Martin Nugent
01254 828060
D3/11/0969

**Planning Application, Ribble Valley District
3/11/0969 Calder Farm, Settle Road, Bolton By Bowland**

SITE PLAN

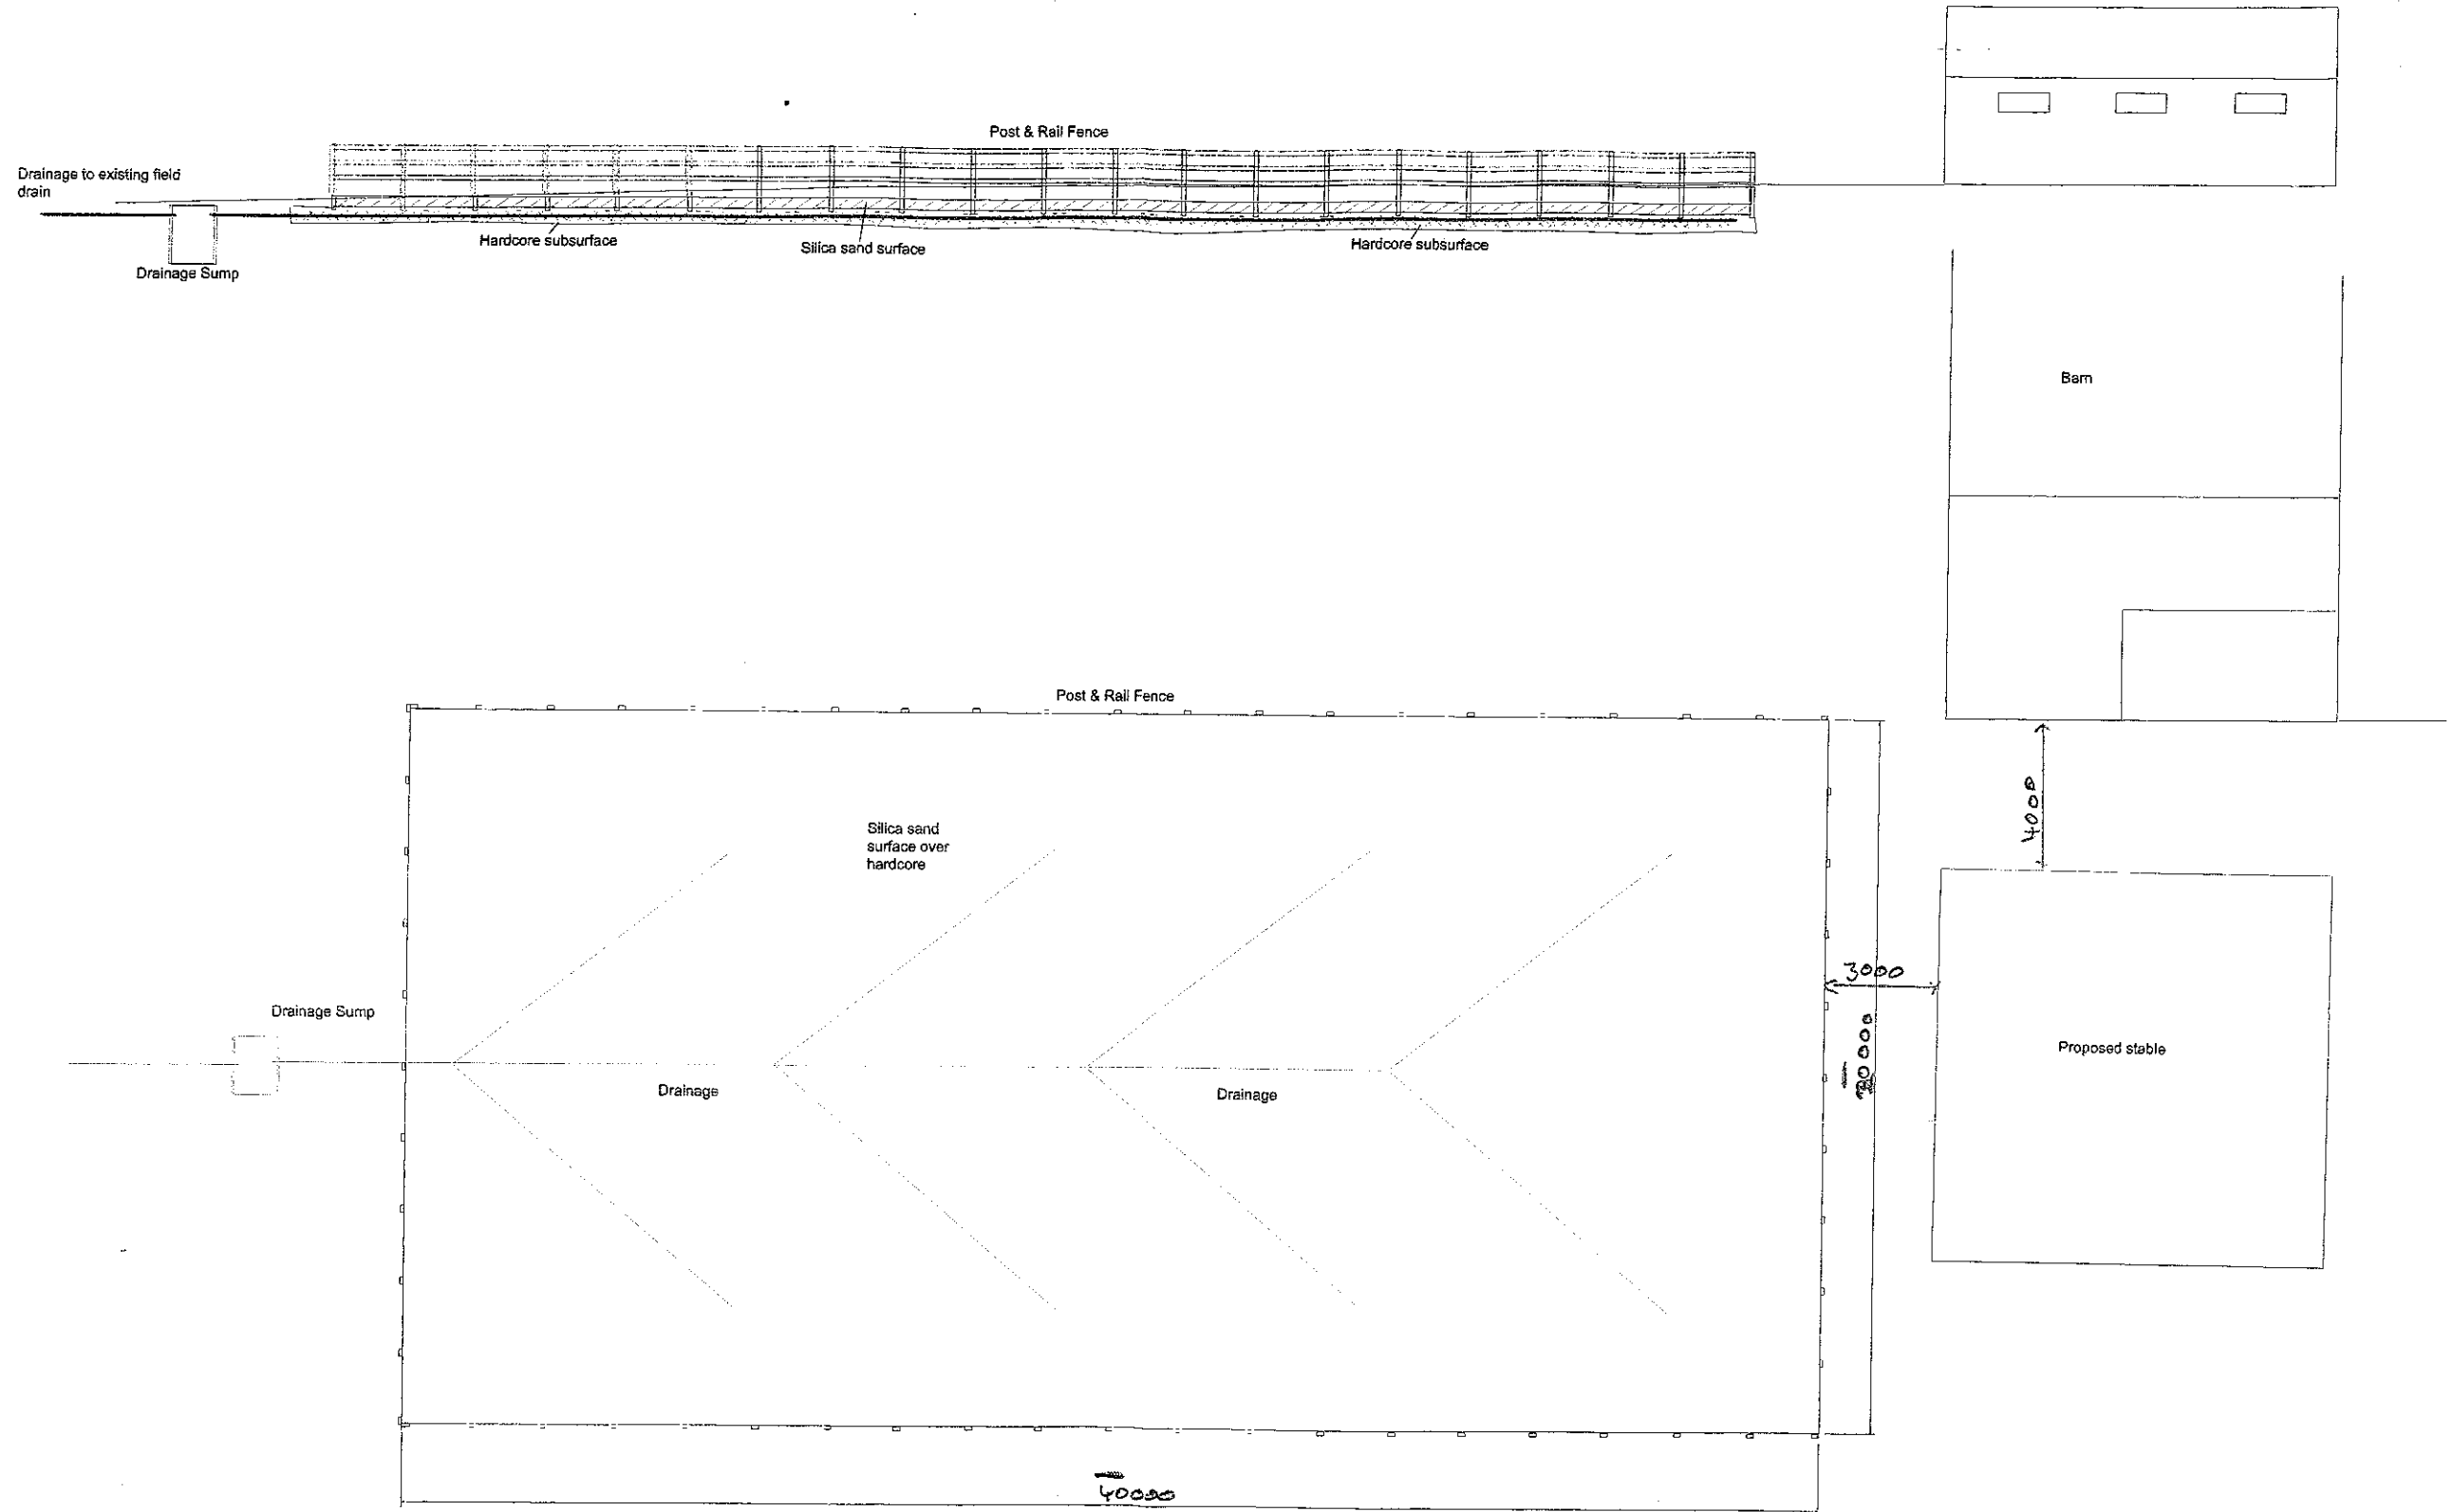
However, there is no gate shown on either the site plan or other application drawings. I would be grateful for confirmation from the applicant that there is no proposal to include a gate at the access to the development, as the inclusion of a gate would require alterations to the design.
